# **Planning Inspectorate NSIP ref no TR010037**

## **A47 – A11 Thickthorn Junction**

**Submission from Richard Hawker IP ref No 20028387 Date: 20 March 2022**

### **Deadline D10 comments**

Figure 4.13: AADTs in Scheme area – Base and Do Minimum and Do Something

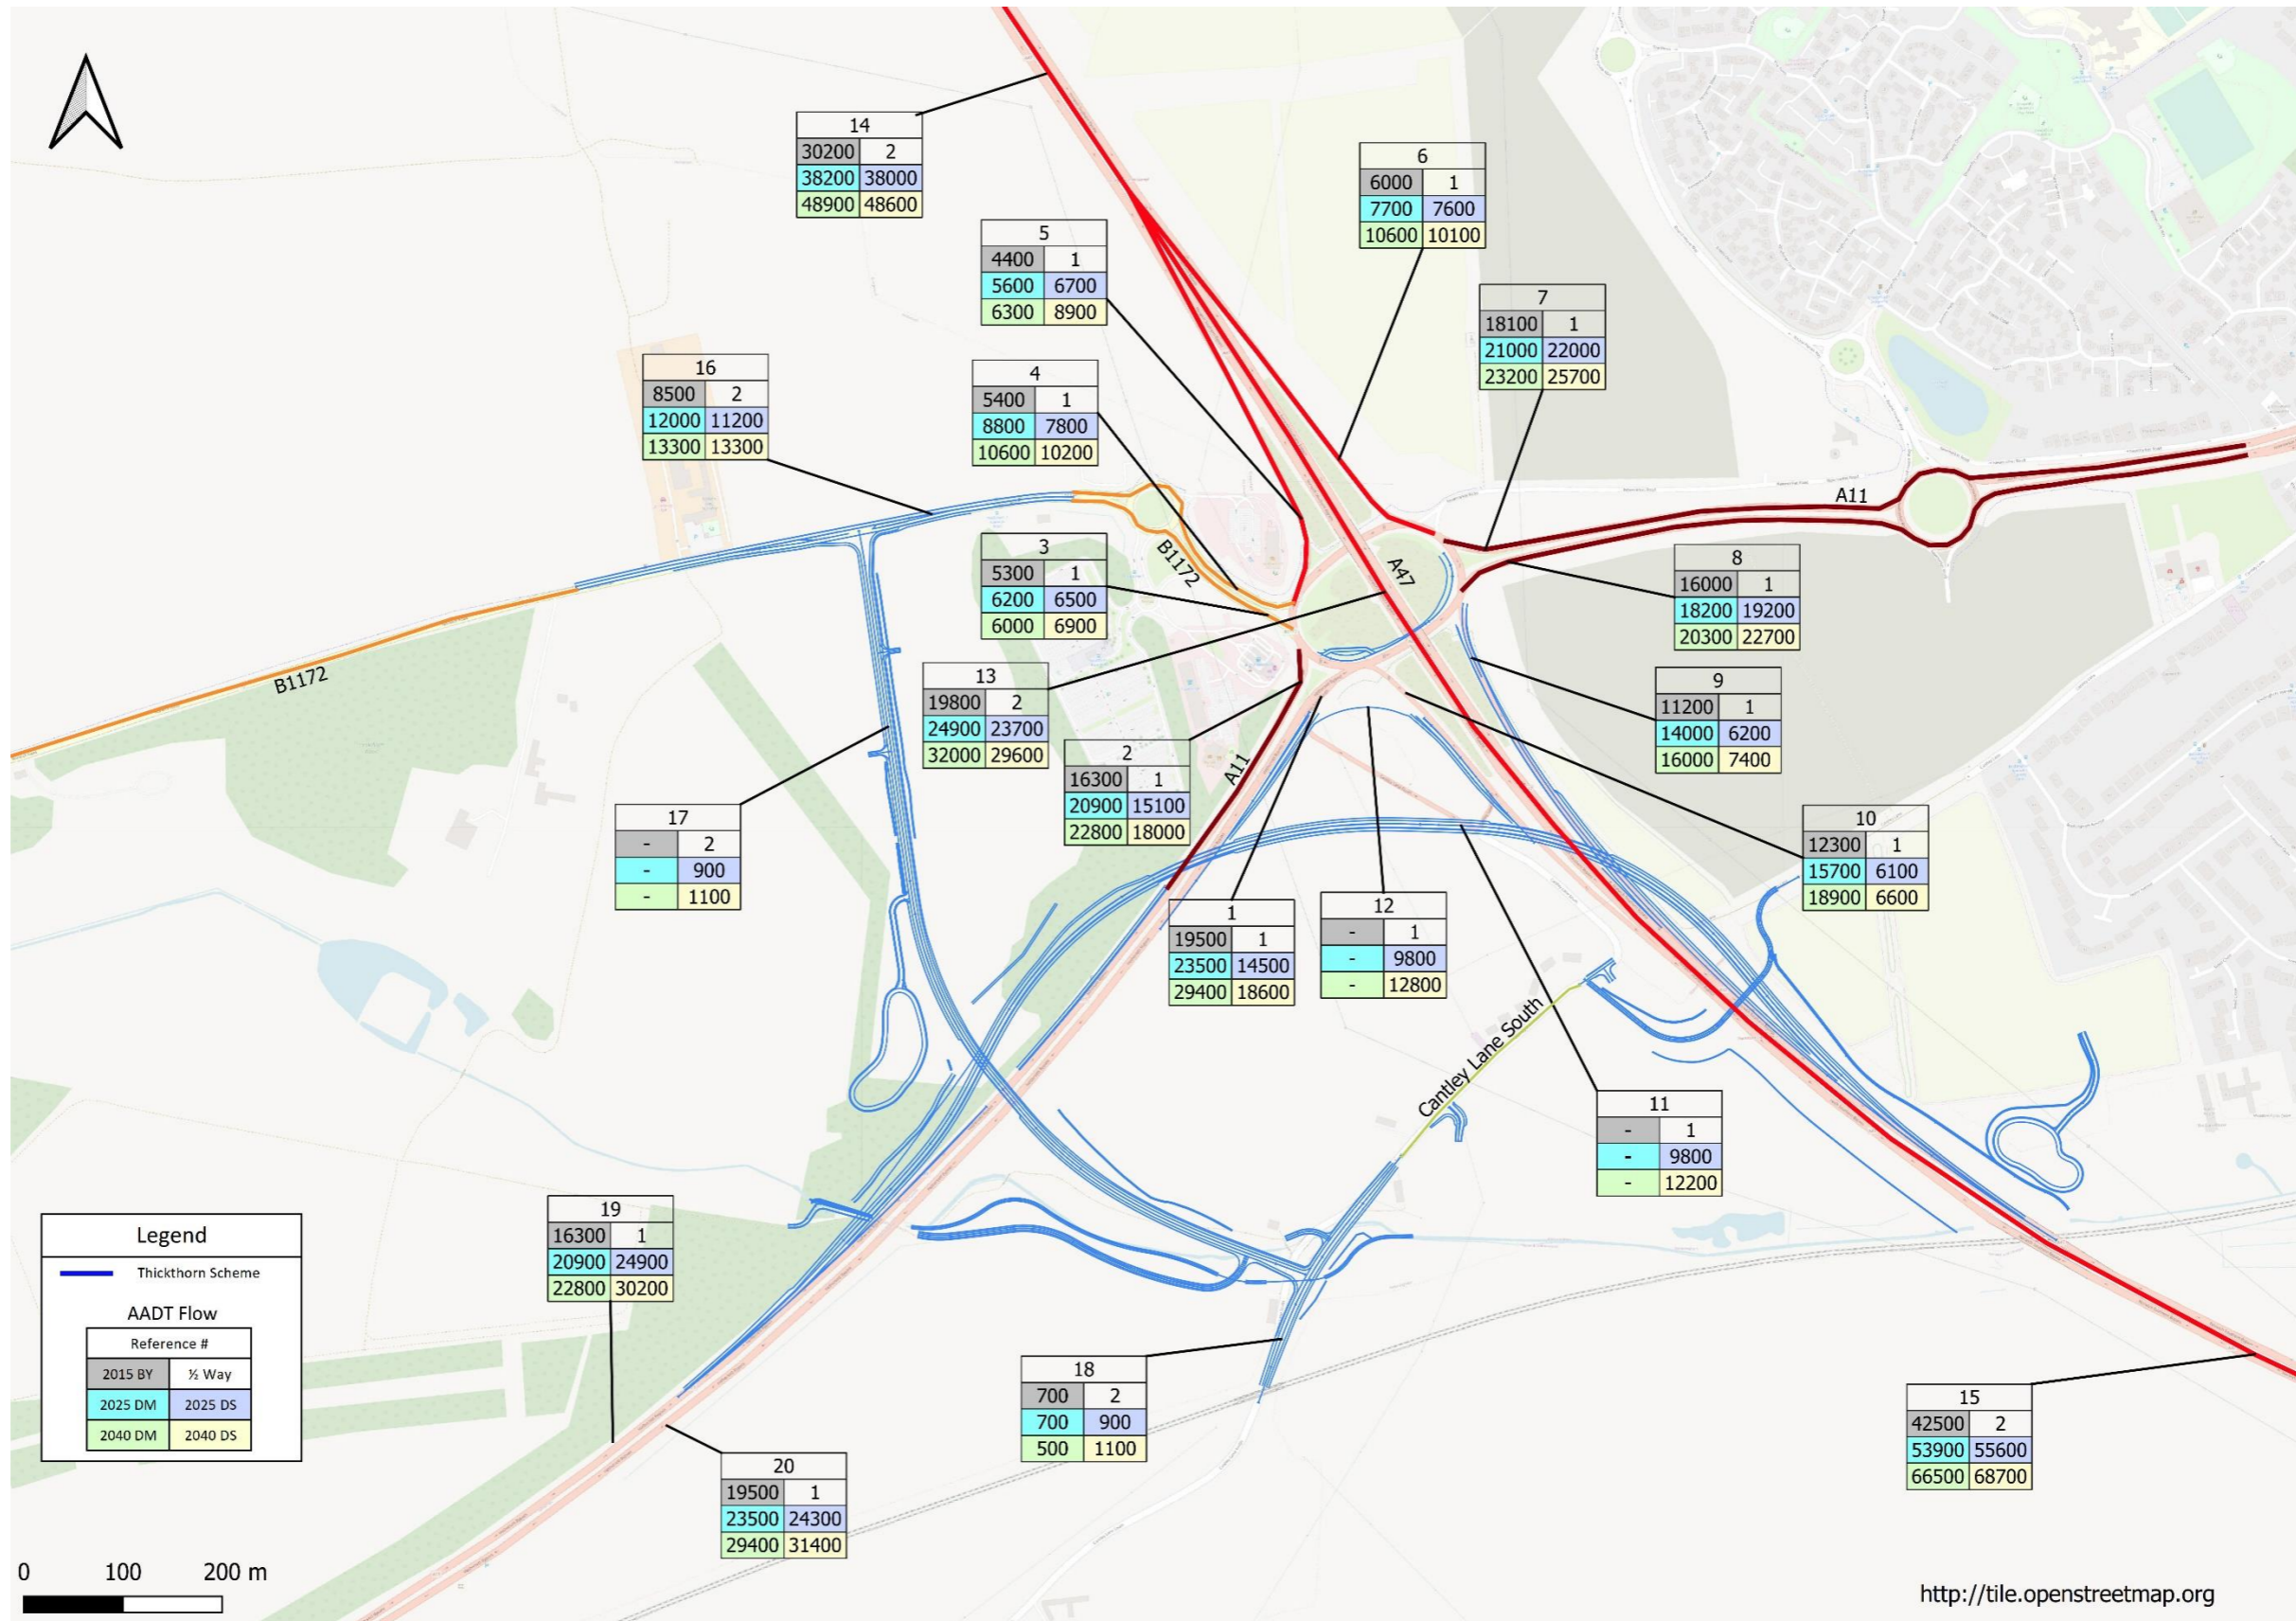
However, those figures *are* shown on the AADT diagram and they are in my tables Figs 1 – 3, showing the numbers making up the total traffic away from the roundabout on each of the five roads. It is not possible to do the same for traffic entering. This summary was done to check that there were no anomalies (as found on the A47 North Tuddenham modelling). Tables 1 – 3 are for BY 2015, DM2025 and DS2025 respectively, and are based on the figure 4.13 in APP-125. The first figure (bold) is the total on that road, and the figures below it are those flows which contribute to it. There are no obvious anomalies.

Figures for the dedicated slip lanes linking A47NWbnd to A11SWbnd, and vice versa, in the DS2025 scenario, predict that around 9,800 vehicles of roughly 25,000 will make that turn, i.e. around 35 – 40%. Now considering the BY2015 figures, and taking that percentage of vehicles from those entering the roundabout from the total A47NWbnd show that a total of 660 vehicles could be diverted from the roundabout in the AM peak and 530 in the PM peak. (The same number would be expected to make the turn in the opposite direction). If other sliproads were built from A11SWbnd to A47SEbnd, and A47SEbnd to A11NEbnd, and they took just 15% of the traffic entering the roundabout (a conservative estimate), a total of around **980** vehicles could be diverted from entering the roundabout in the AM peak, (15% of

the total 6538) and **920** in the PM peak (14% of the total 6507). This is thus *more* than the roughly **660** which would be taken by the underpass (based on 2015 figures).

Thus dedicated sliproads could likely achieve a better result than an underpass.
